12 Brookmans Avenue,
Brookmans Park,
Hatfield, AL9 7QJ. Herts

23rd February 2017

Thank you for your letter dated 20th Feb 2017 concerning application reference 6/2016/1778/FULL.

Drawing Title
PROPOSED PLANS/SECTION/
ELEVATIONS

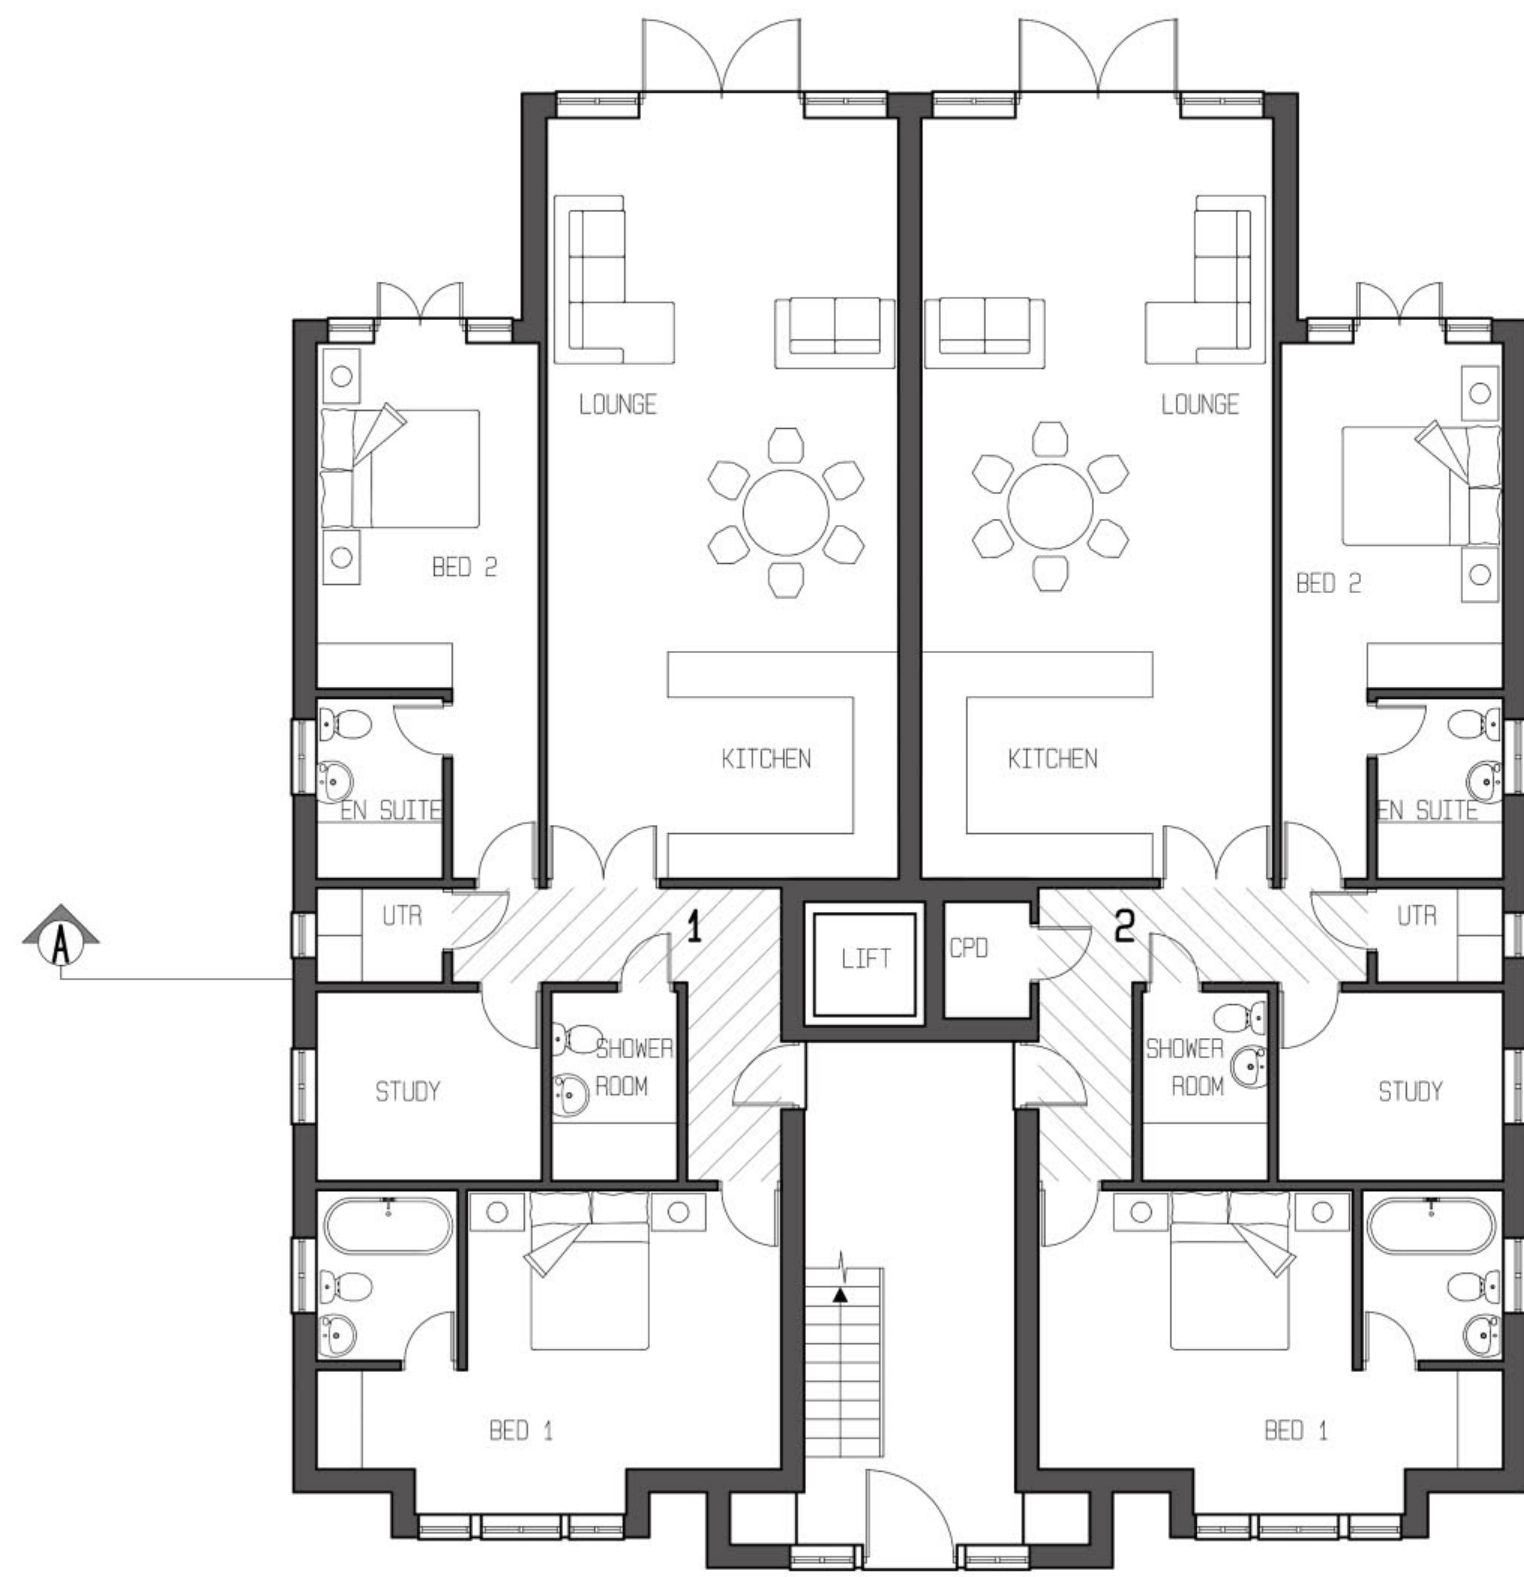
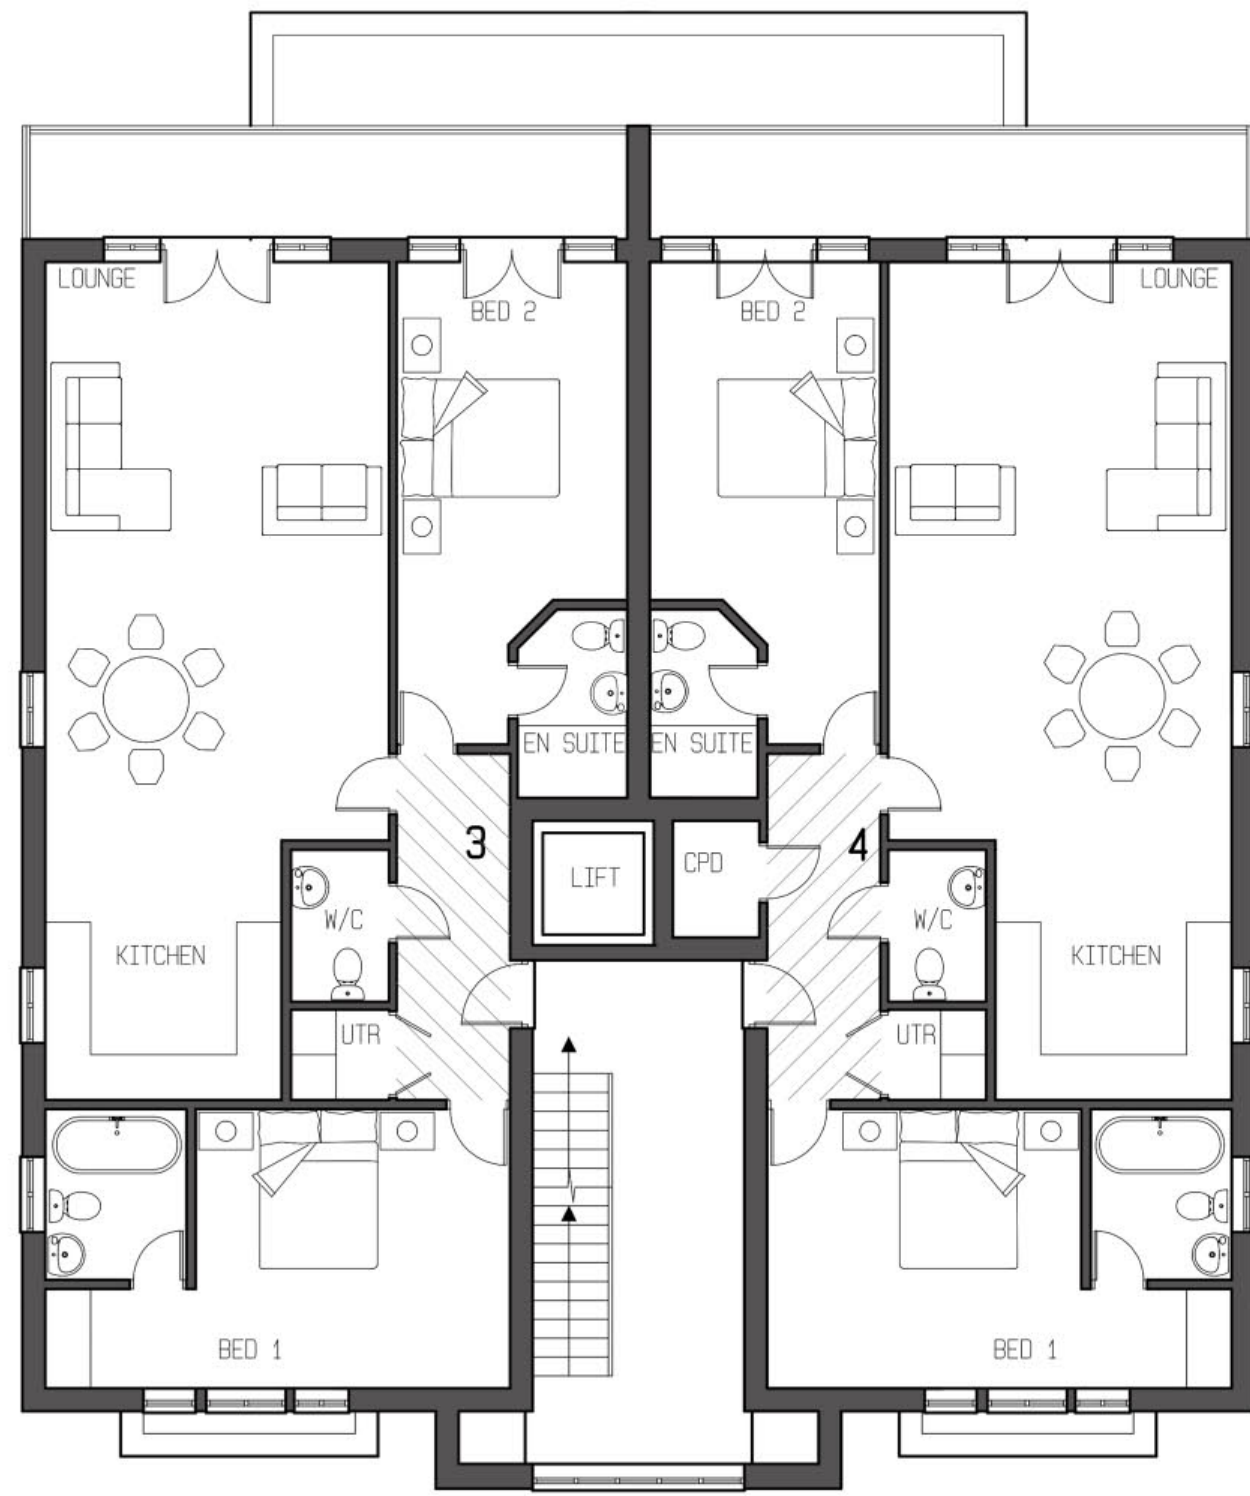
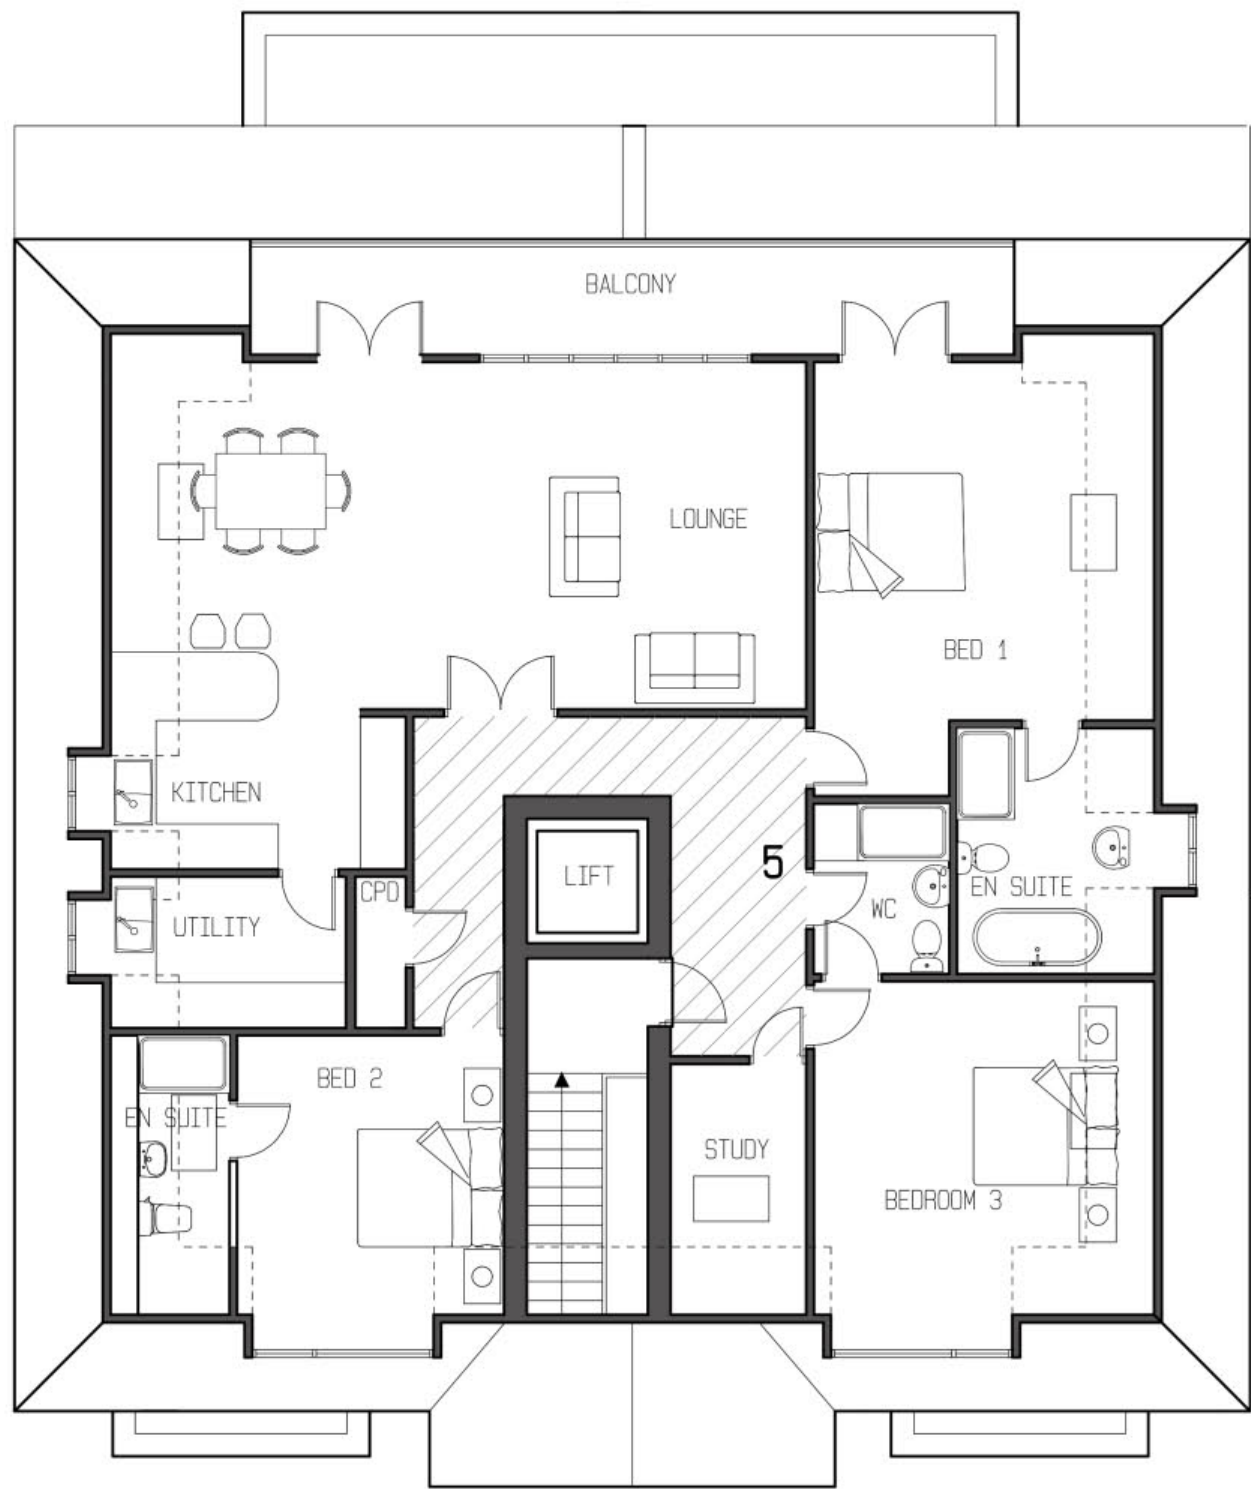
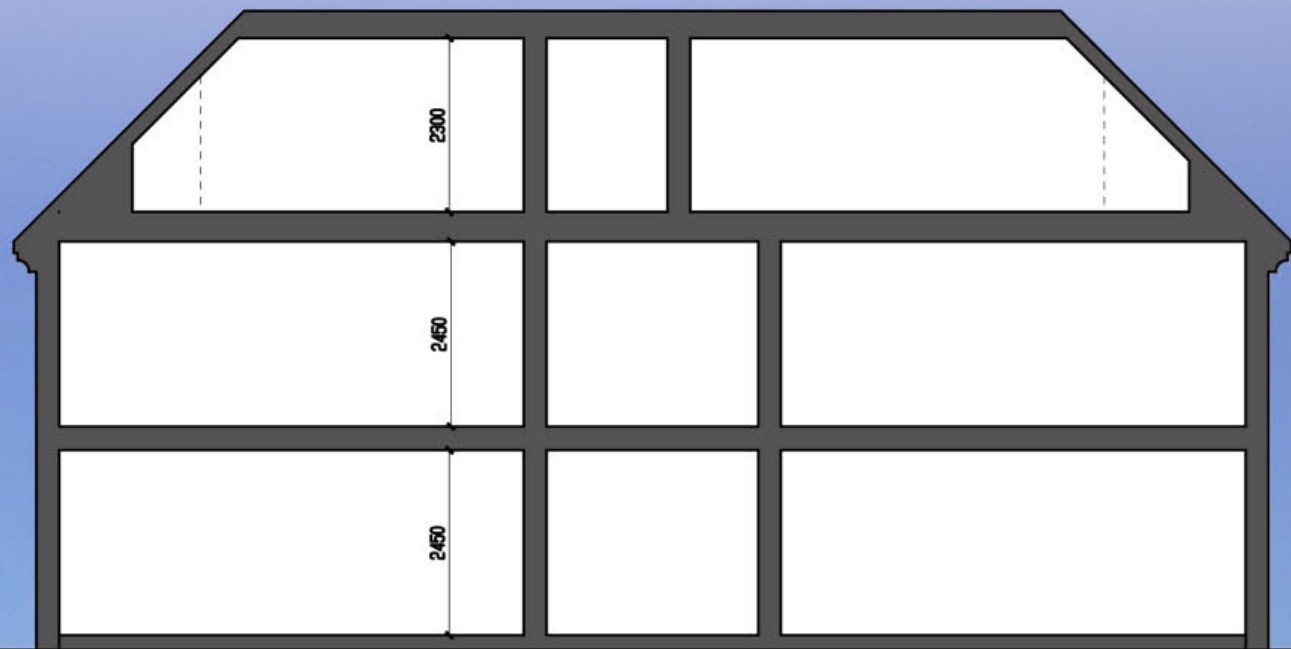
Also, In reviewing the amended drawings on file I note the dormer windows at the front of the building are still shown despite my earlier objection to these because they are completely out of character with adjacent buildings and directly overlook my property. May I also observe that there remains a shortage of car parking space on the revised drawings, quite insufficient parking for up to 10 vehicles likely to be needed to serve five flats.

Drawing Title
PROPOSED SITE PLAN AND
STREET SCENE

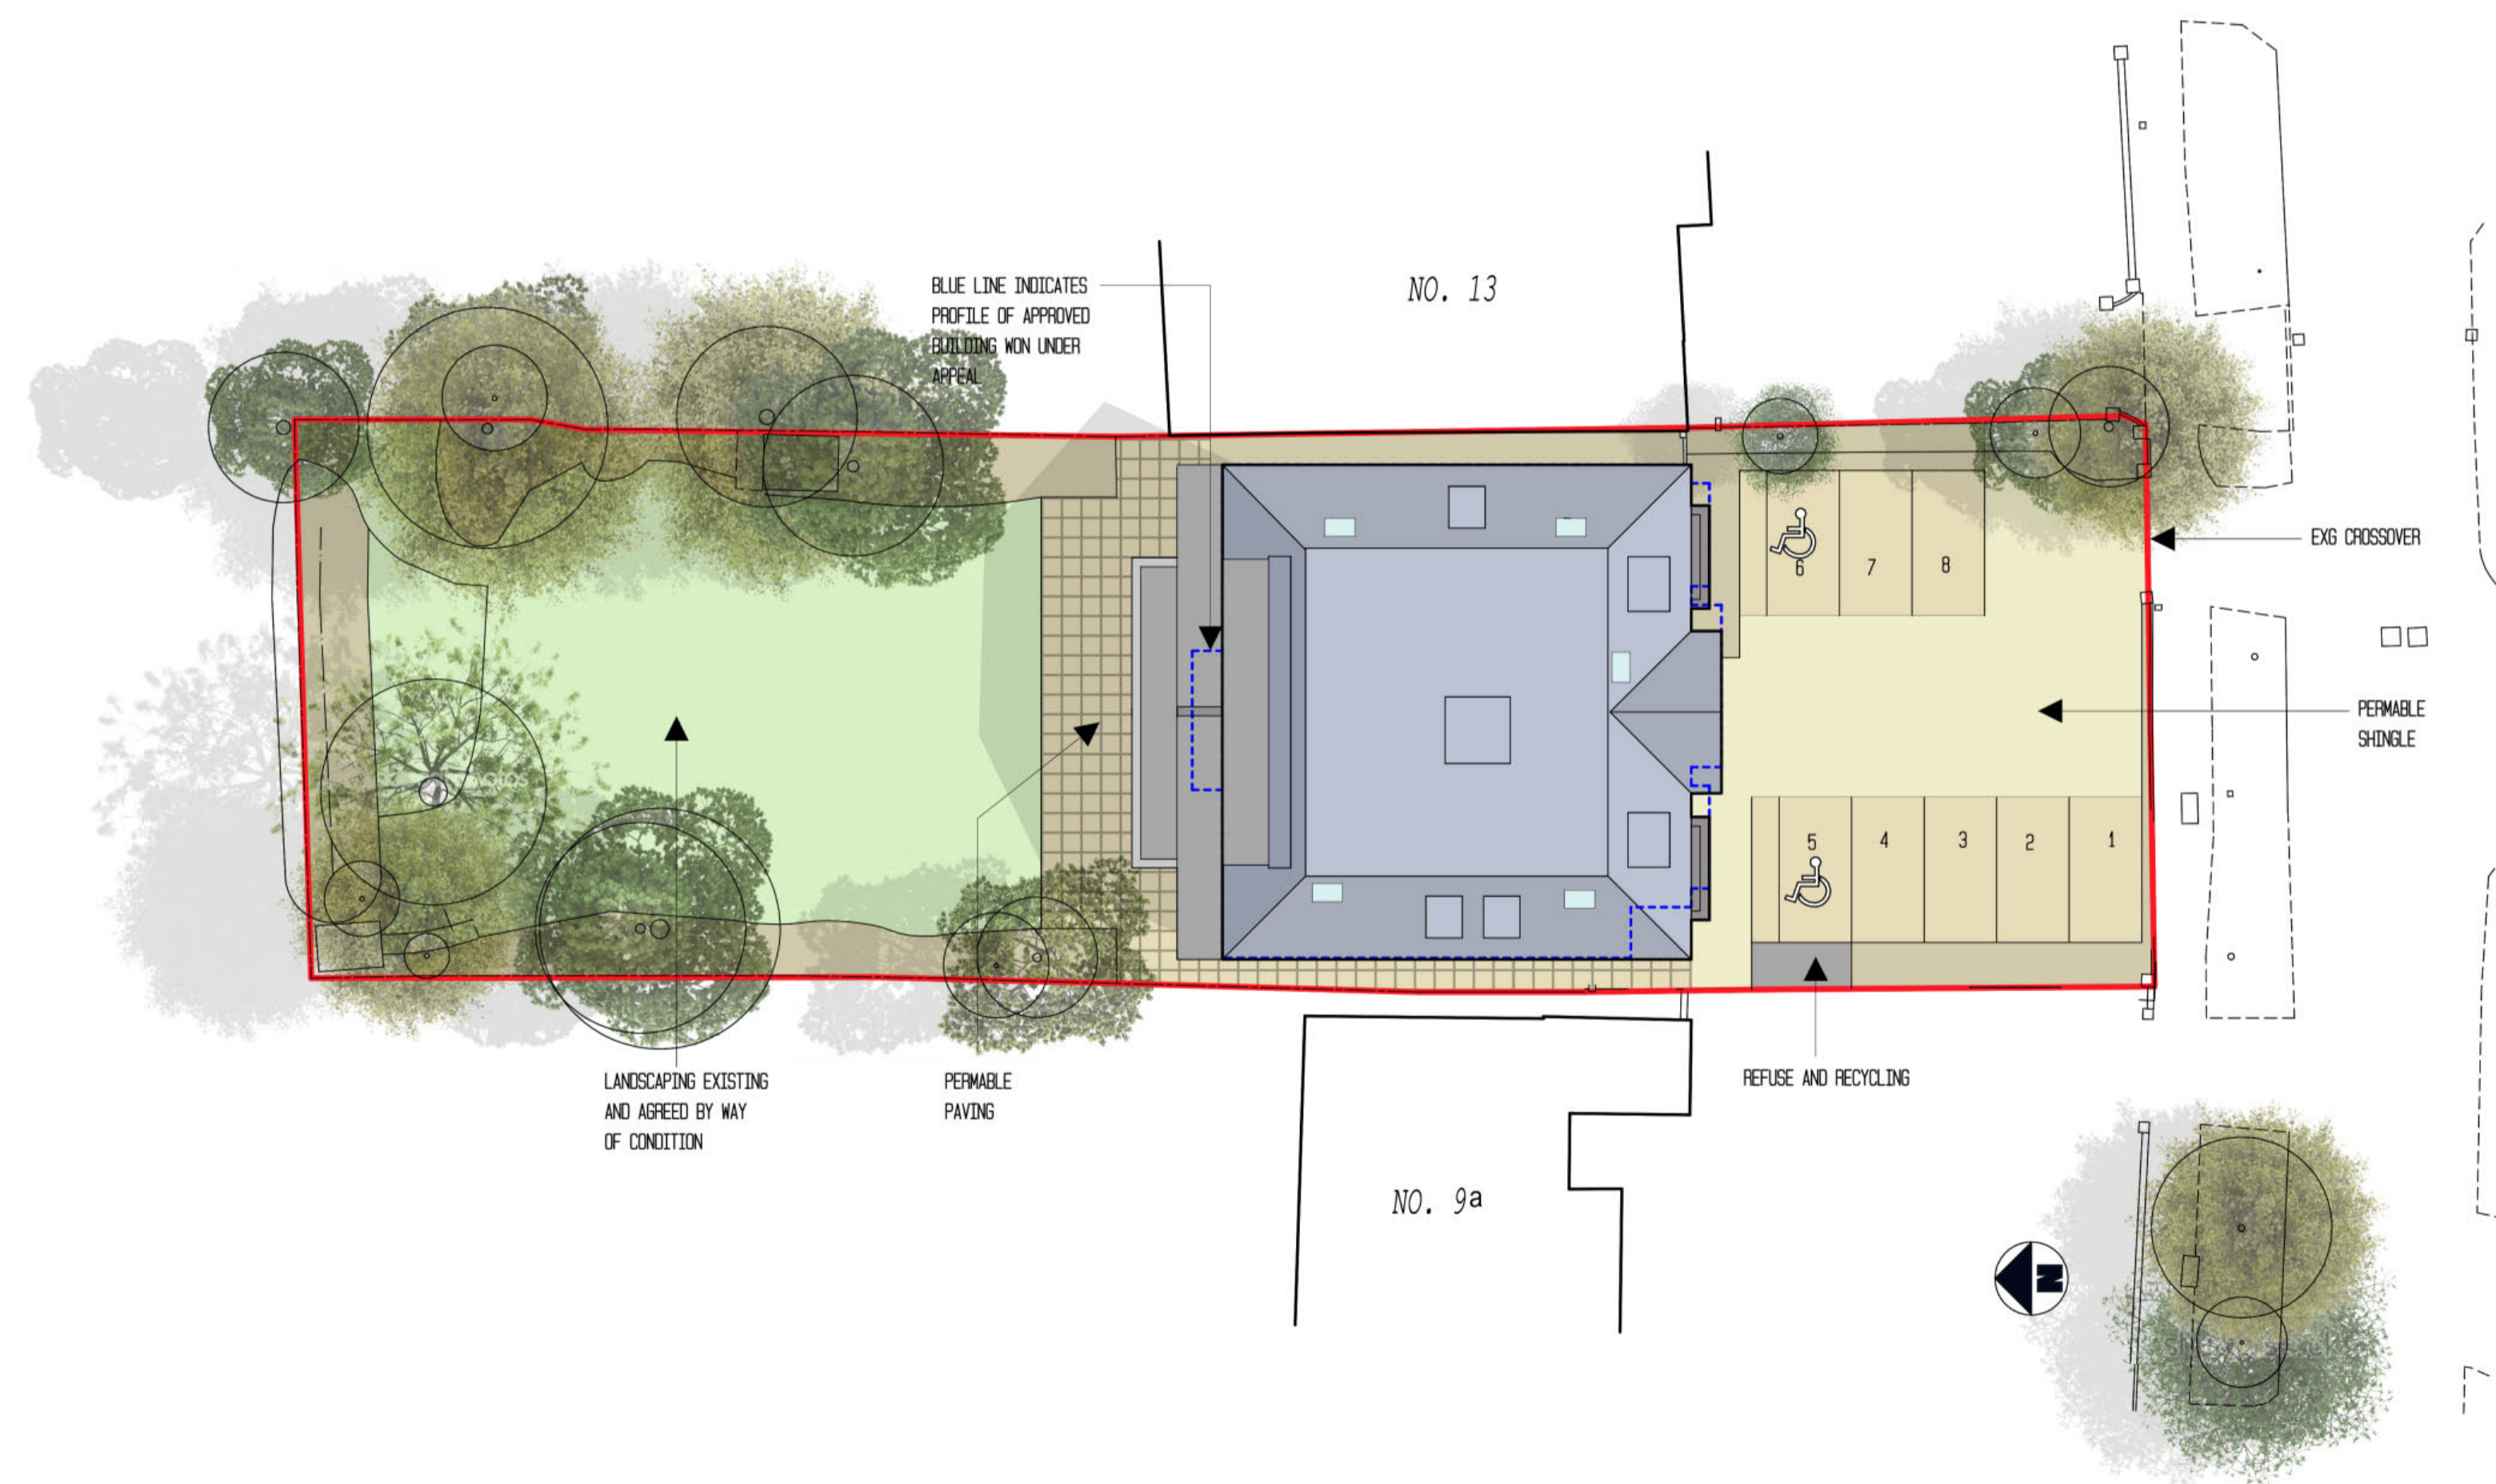
Also there does not appear to be any provision for storing communal refuse bins or the potential 15 standard refuse bins that five flat will require on this property.
